**RE: Monahan Mountain Tree Farm Tracts Large Lot (LL-08-05)
Monahan Mountain Forest Tracts Large Lot (LL-08-04)**

TO: Trudie Pettit, Community Development Services
FROM: Randy Carbary, Planner II *rc*
DATE: May 30, 2008
SUBJECT: Monahan Mountain Forest Tracts Large Lot Subdivision LL-08-04

TO: Trudie Pettit, Community Development Services
FROM: Randy Carbery, Planner II *rc*
DATE: May 30, 2008
SUBJECT: Monahan Mountain Tree Farm Tracts Large Lot Subdivision LL-08-05

MONAHAN MOUNTAIN FOREST TRACTS LARGE LOT SUBDIVISION
 A PORTION OF SECTION 14, TWN. 20N., RGE. 13E., W.M.
 KITTITAS COUNTY, WASHINGTON

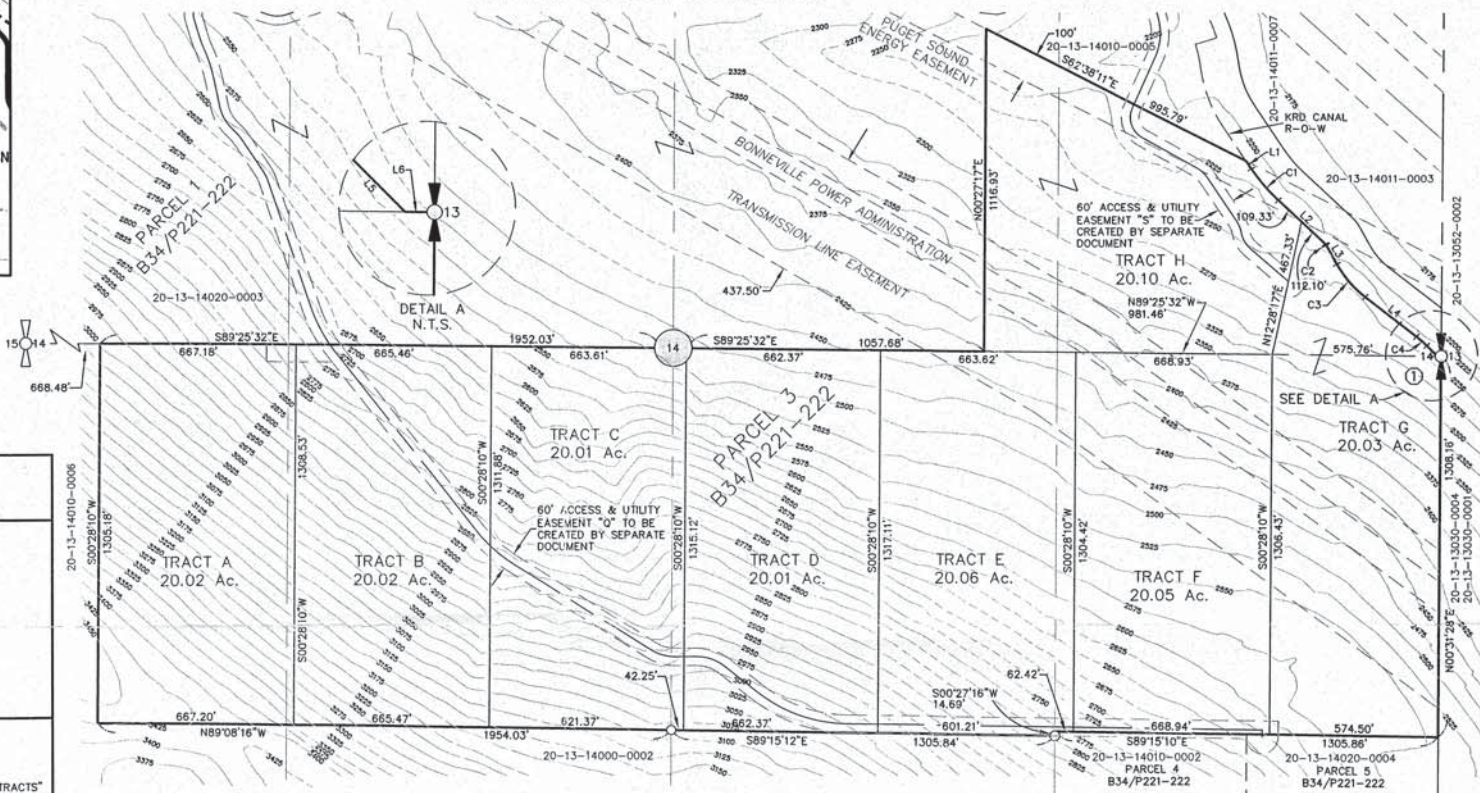
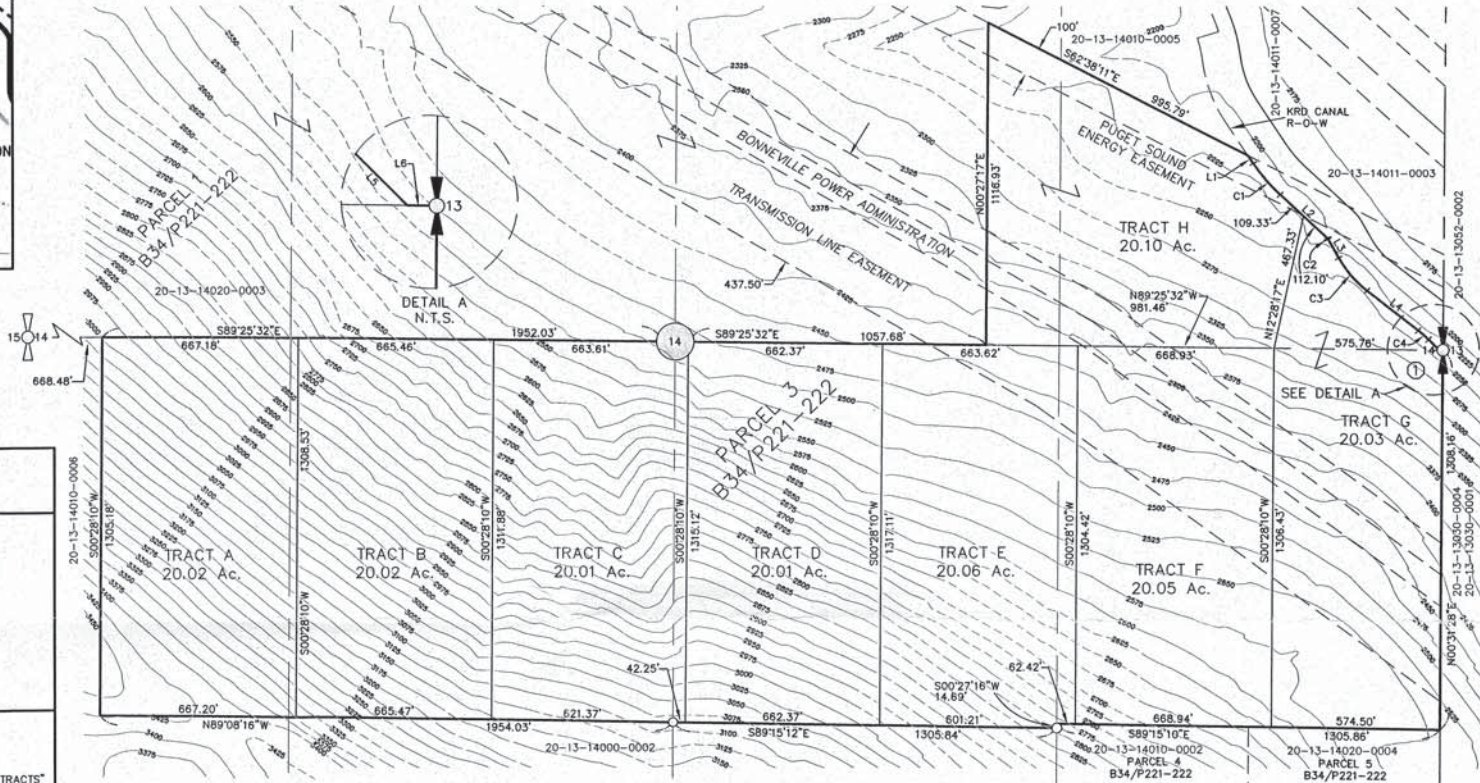
1. Access: The proposed Large Lot Subdivision does not appear to depict any access easement on their application. In order to review the application, the access to all lots shall be clearly depicted on the face of the plat.

**MONAHAN MOUNTAIN TREE FARM TRACTS LARGE LOT SUBDIVISION**  
 A PTN. OF THE NORTH 1/2 OF SEC. 14, TWN. 20N., RGE. 13E., W.M.  
 KITTITAS COUNTY, WASHINGTON

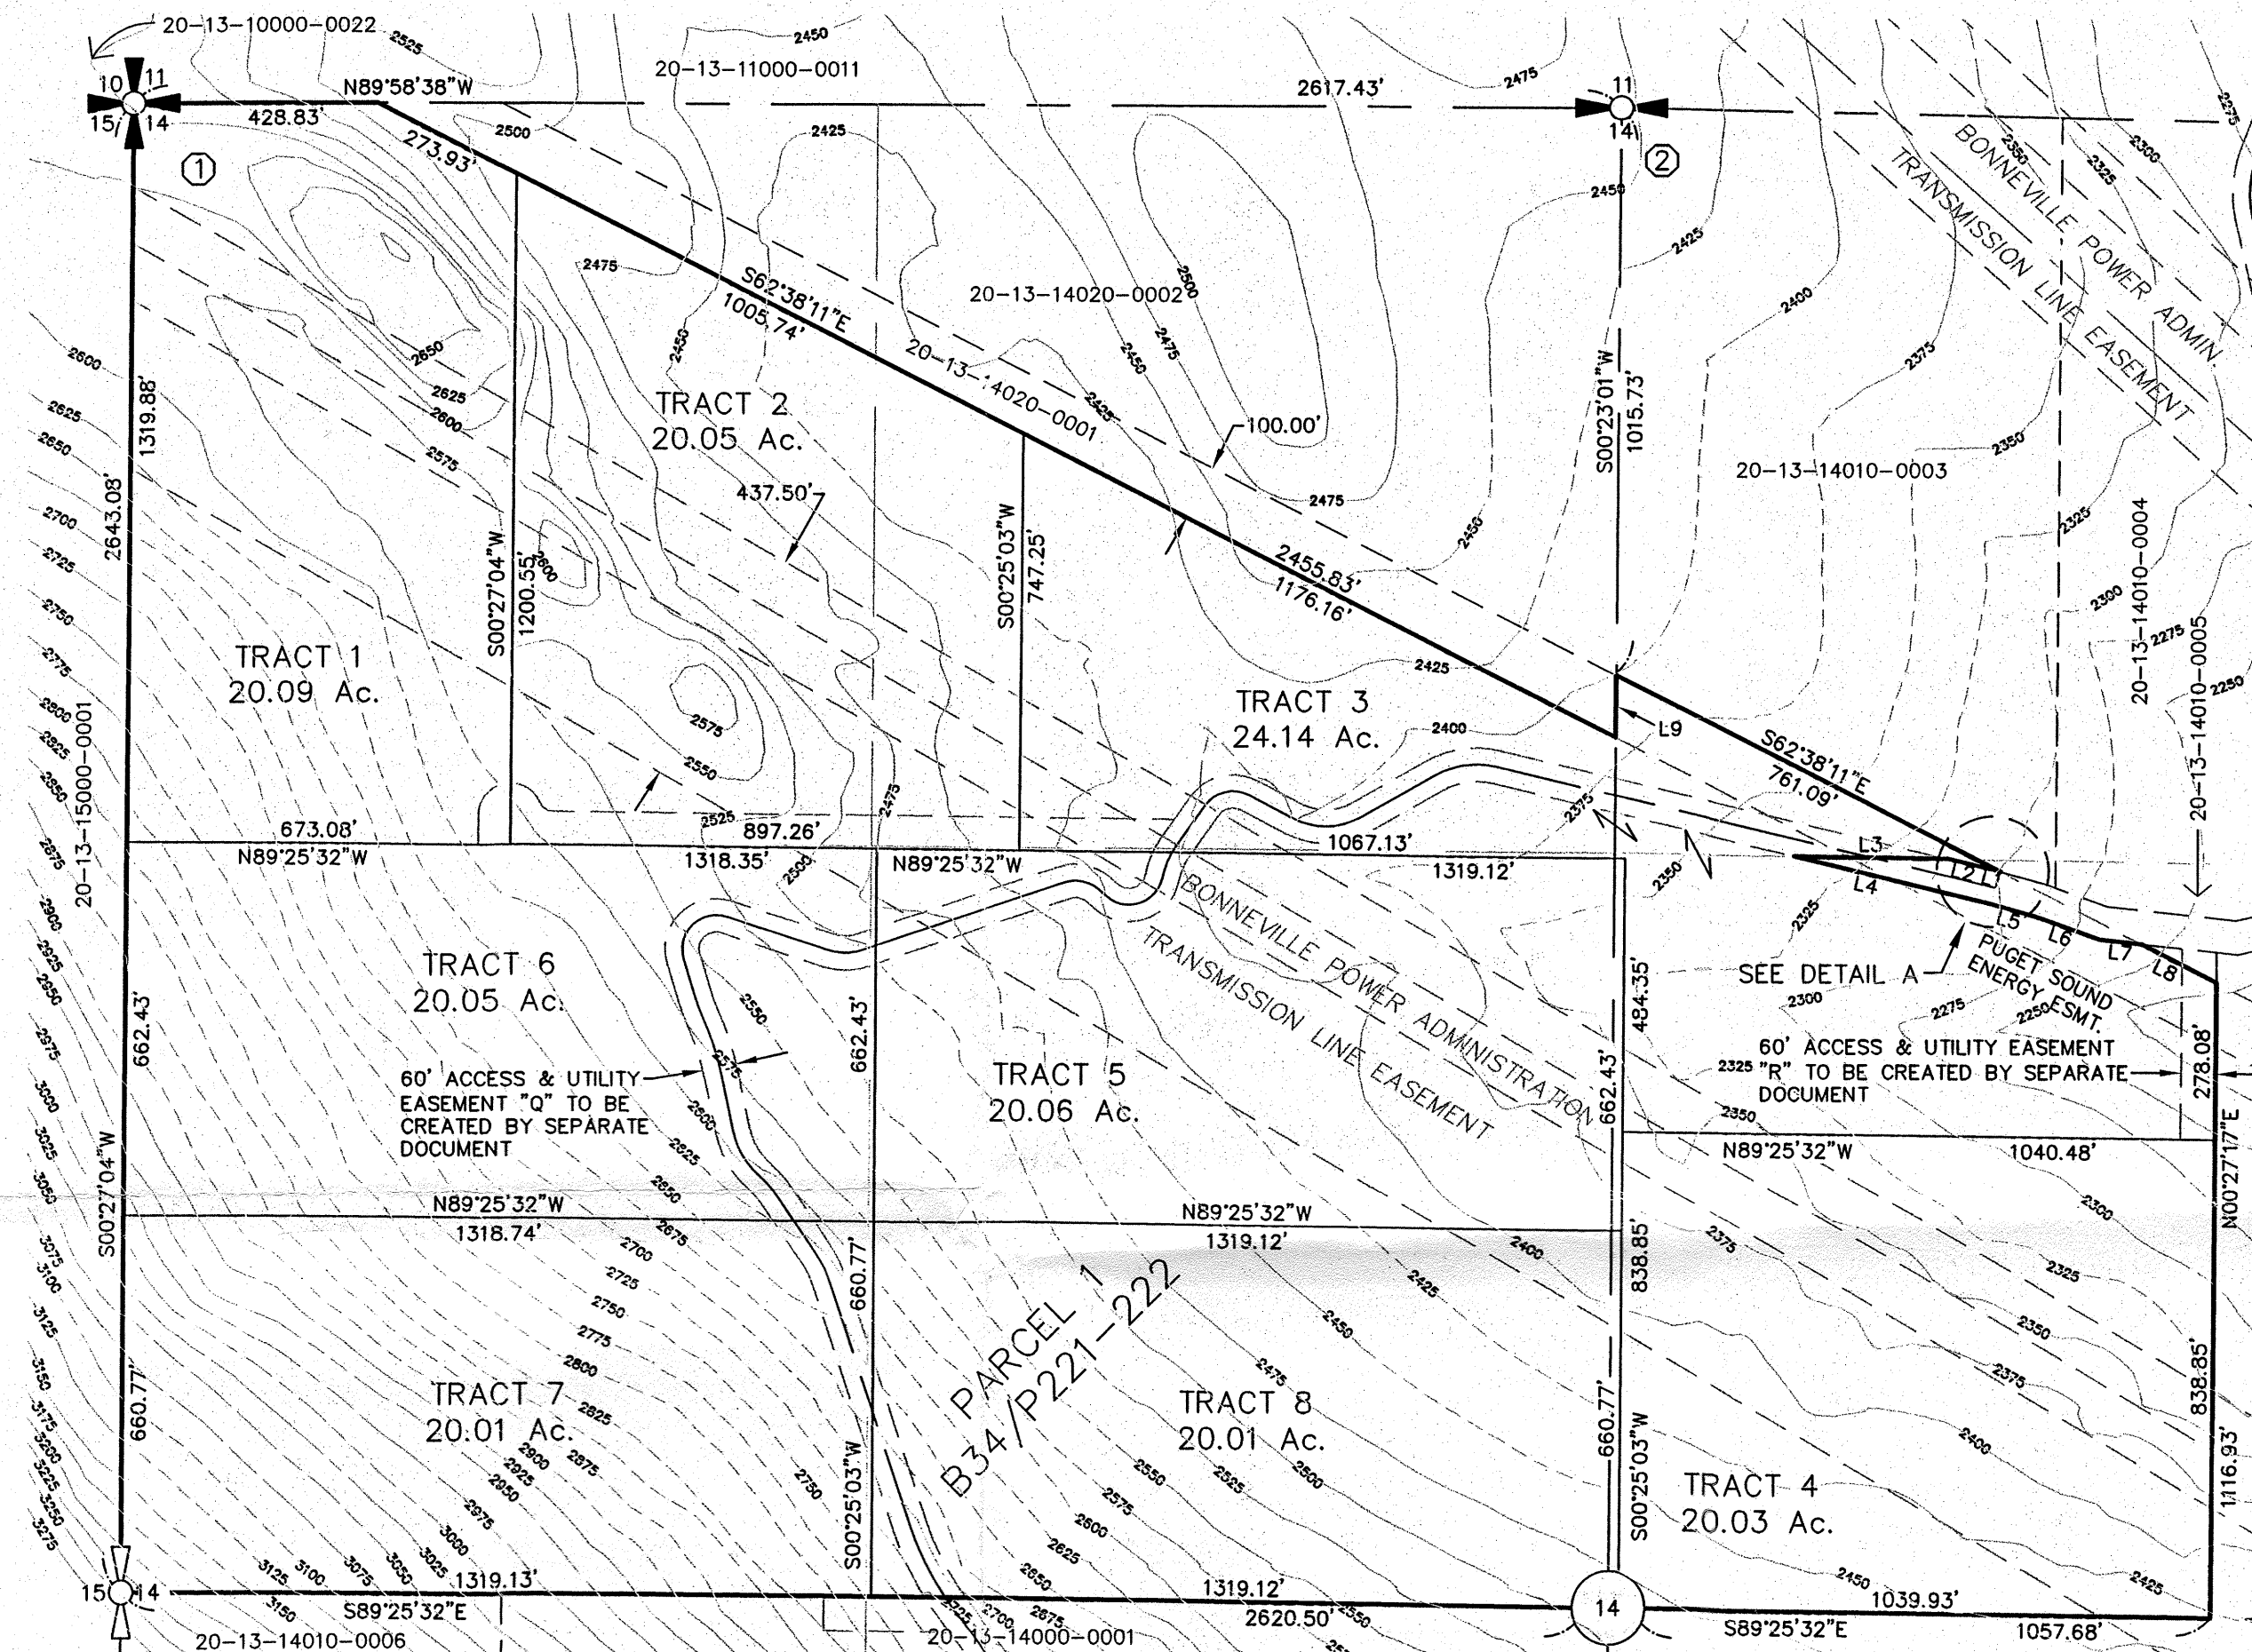
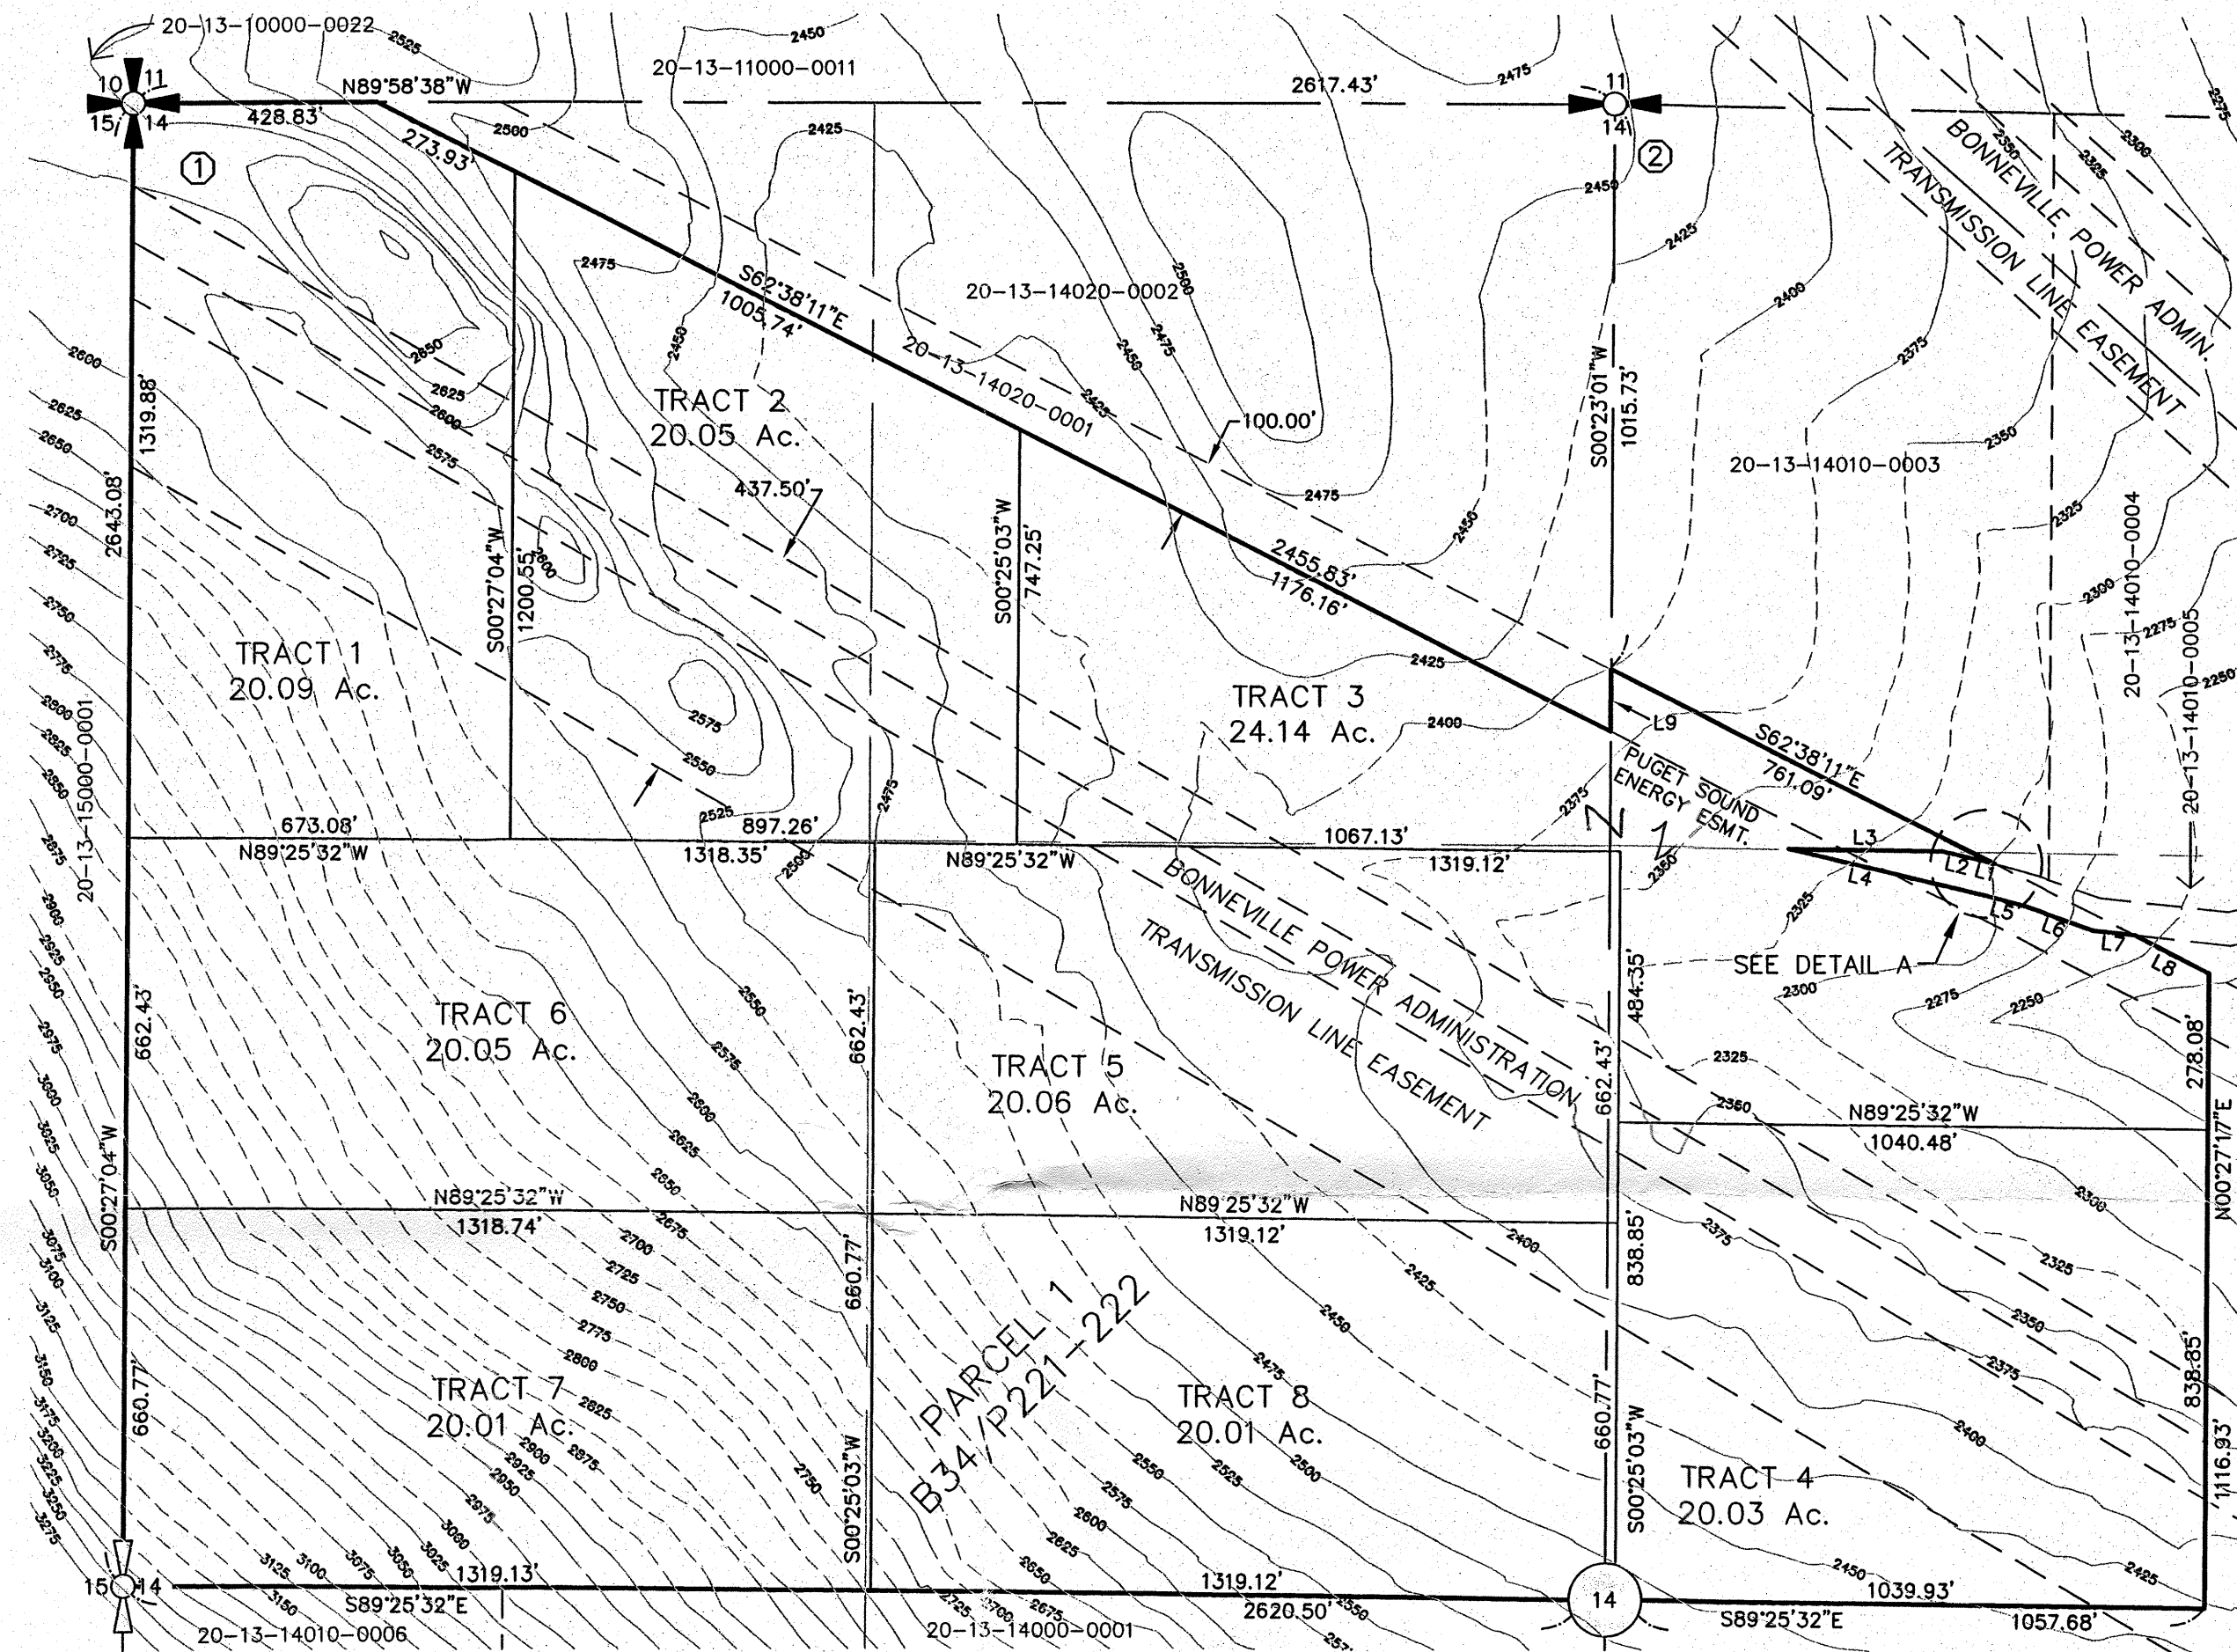
1. Access: The proposed Large Lot Subdivision does not appear to depict any access easement on their application. In order to review the application, the access to all lots shall be clearly depicted on the face of the plat.
